**From:** Contact Centre (CRM) <contact@ribblevalley.gov.uk>  
**Sent:** 01 July 2022 23:03  
**To:** Planning  
**Subject:** Planning Application Comments - 3/2022/0530 FS-Case-433893046

**Planning Application Reference No.:** 3/2022/0530

**Address of Development:** Preston Road, Ribchester, Lancs PR3 3XL

**Comments:** We have the following concerns regarding the planning application 3/2022/0530 which details changes to the original application 3/2021/0595 for a Heliculture business and holiday lets on land off Preston Road in Ribchester. [REDACTED]

21/55/4C

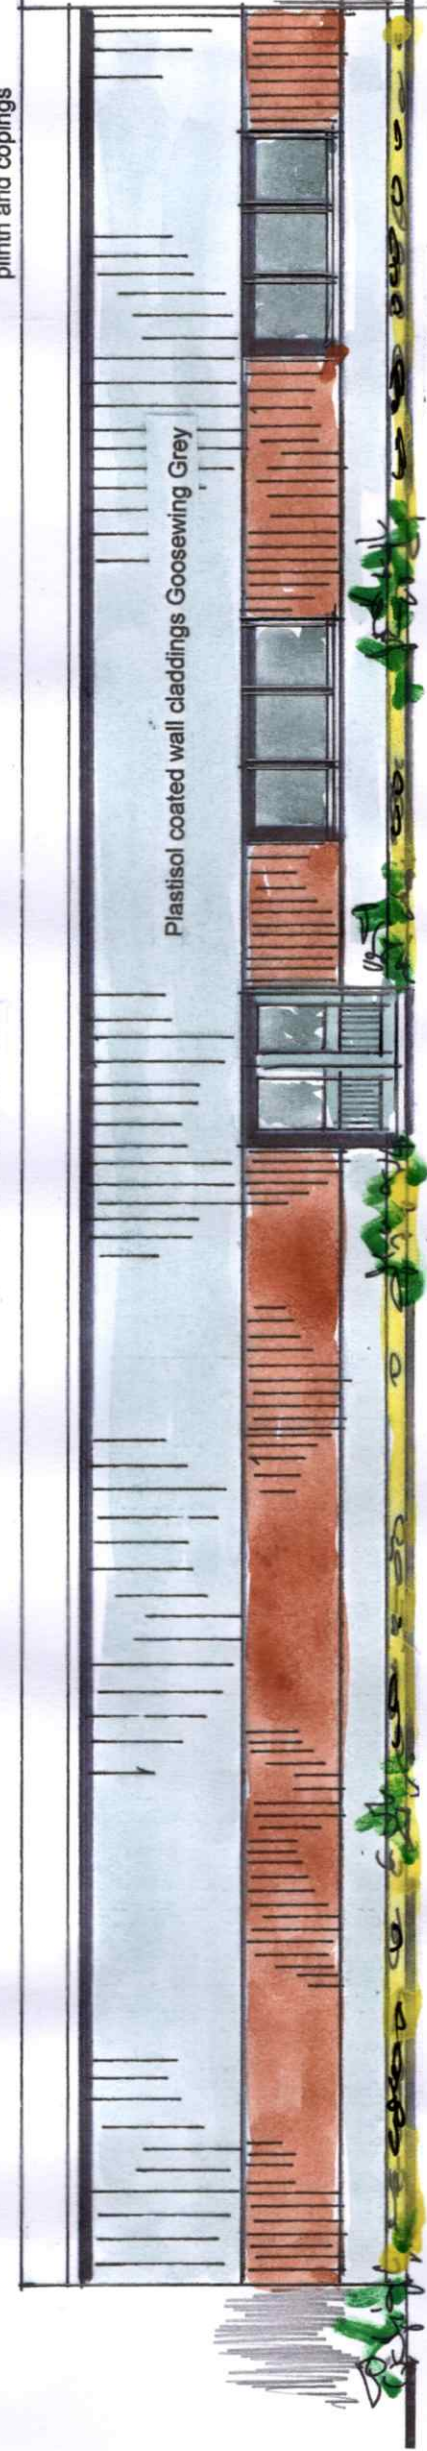
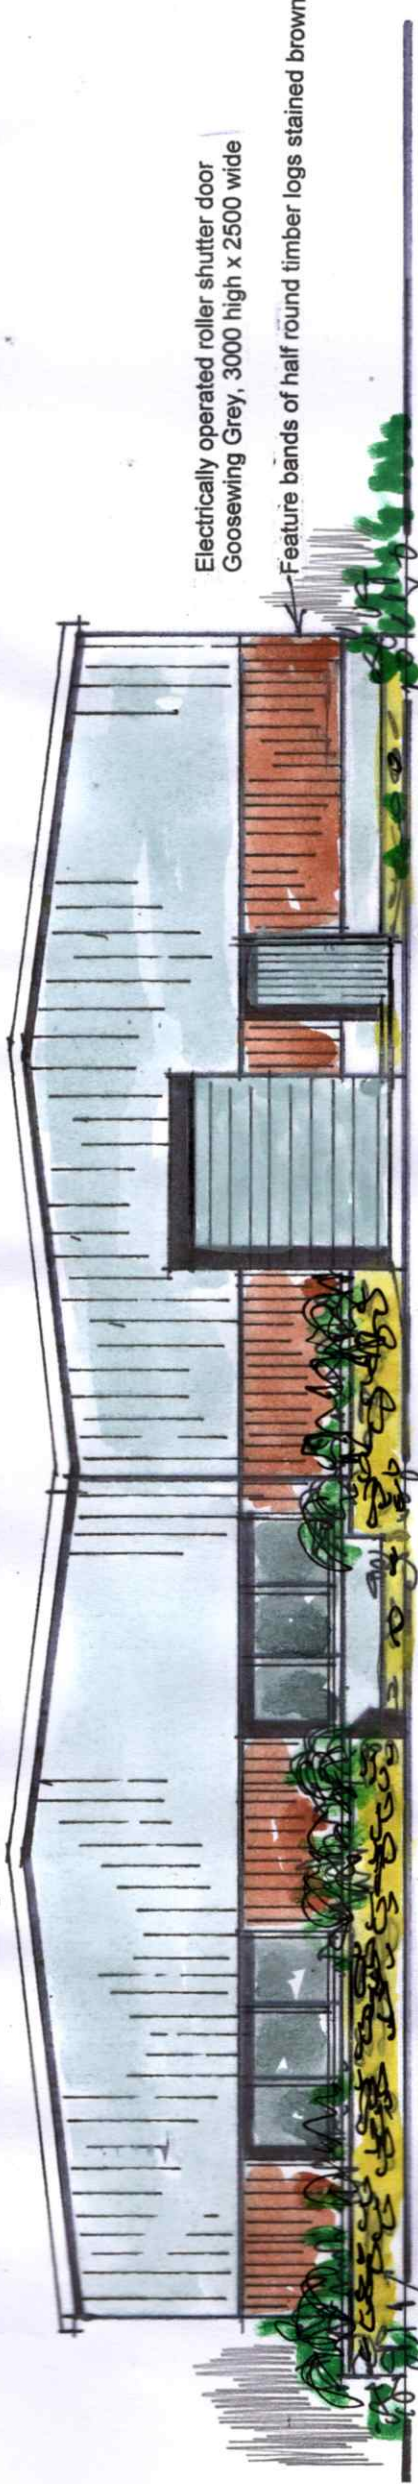
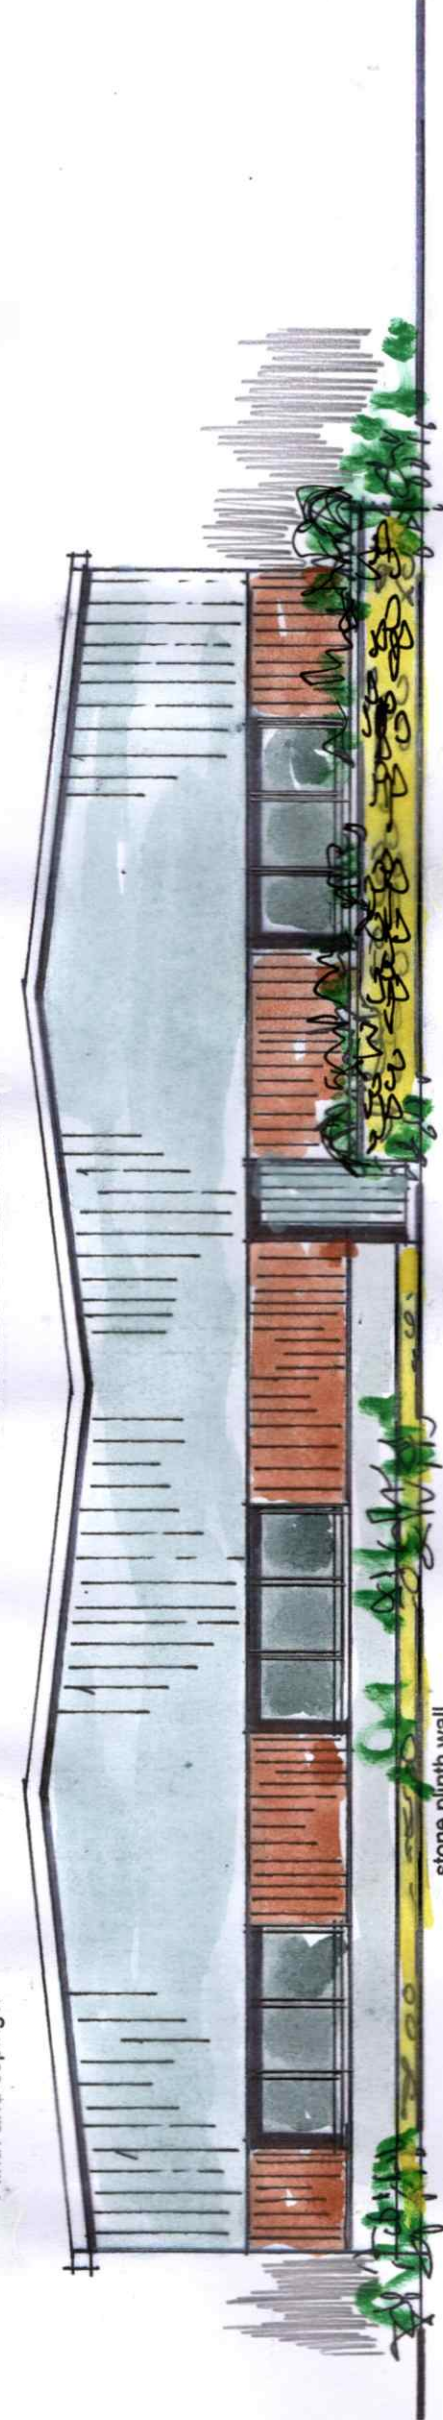
We believe they should stick to the original plan for a green building which would blend into the natural environment much better than the newly proposed grey finish, which would look more like an ugly industrial building, completely out of character with the location. The residents on Preston Road will have to look down on this building for many years to come, so the more it blends in, the better. The light grey colour of the roof is already imposing enough. We do see the addition of more wooden cladding to be an improvement.

This should not alter the fact that permission was granted for green cladding. When finished the building should be green as agreed.

The proposed amendments to the external materials has already been refused, reason given was to ensure materials are appropriate to the locality. This latest application to amend materials to goosewing grey will have a very industrial appearance and is surely not in keeping with the rural location. The main building already looks like a factory and is an eyesore. From the proposed elevations 21/55/4C it shows the intention to fit roller shutter doors to the main building. The immense casing for which is already in place but we understood that changes to the elevational details of the building were refused in previous application for variation of condition 2.

**Proposed Development**  
**SITE LAYOUT**

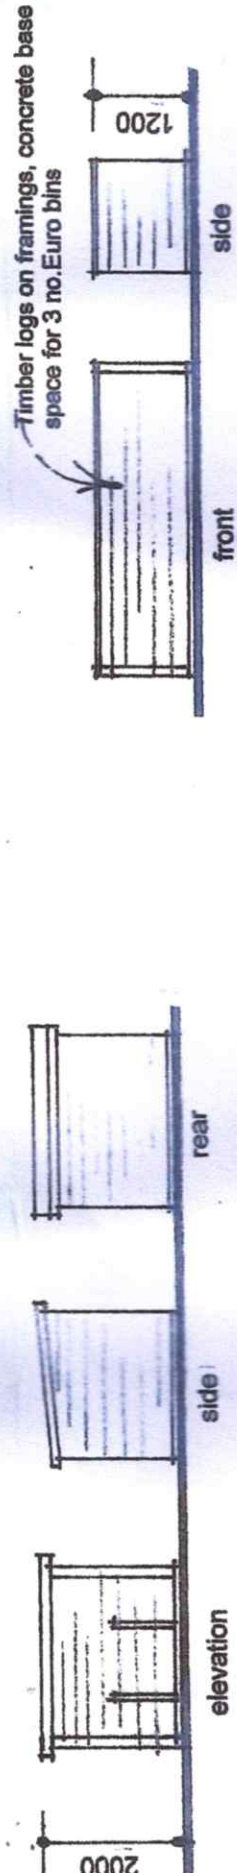
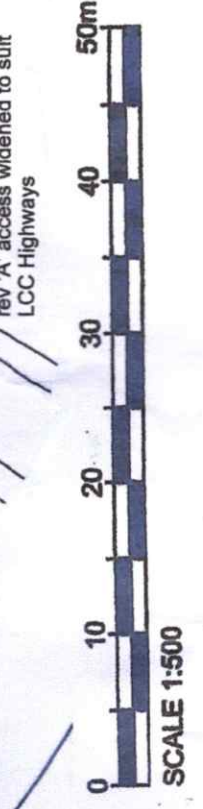
We note the site layout on this application (3/2022/0530); along the entrance are three trees, in accordance with the third (approved) application (3/2022/0595). These were existing trees which we assumed would be preserved; indeed, they were mature trees when I first met the former land owner, some 30 years ago. Now, as a result of the development, one has gone and the other two have been hacked back so severely, that it is doubtful whether they will survive. No doubt, new trees can be planted; but these were lovely old apple trees, of a variety one doesn't see often these days.

**Comments:** The application letter states that the developer no longer seeks to revise layout of approved lodges. However the concrete base for lodge 6 is already positioned as per drawing 21/145/7 (refused last application) and not as in drawing 21/55/5B. Is this not a breach of condition 2?

The site entrance drawing states stone road and the site layout drawing states tarmac and broken stone road not the approved resin bound gravel. Further changes that understand are not approved.
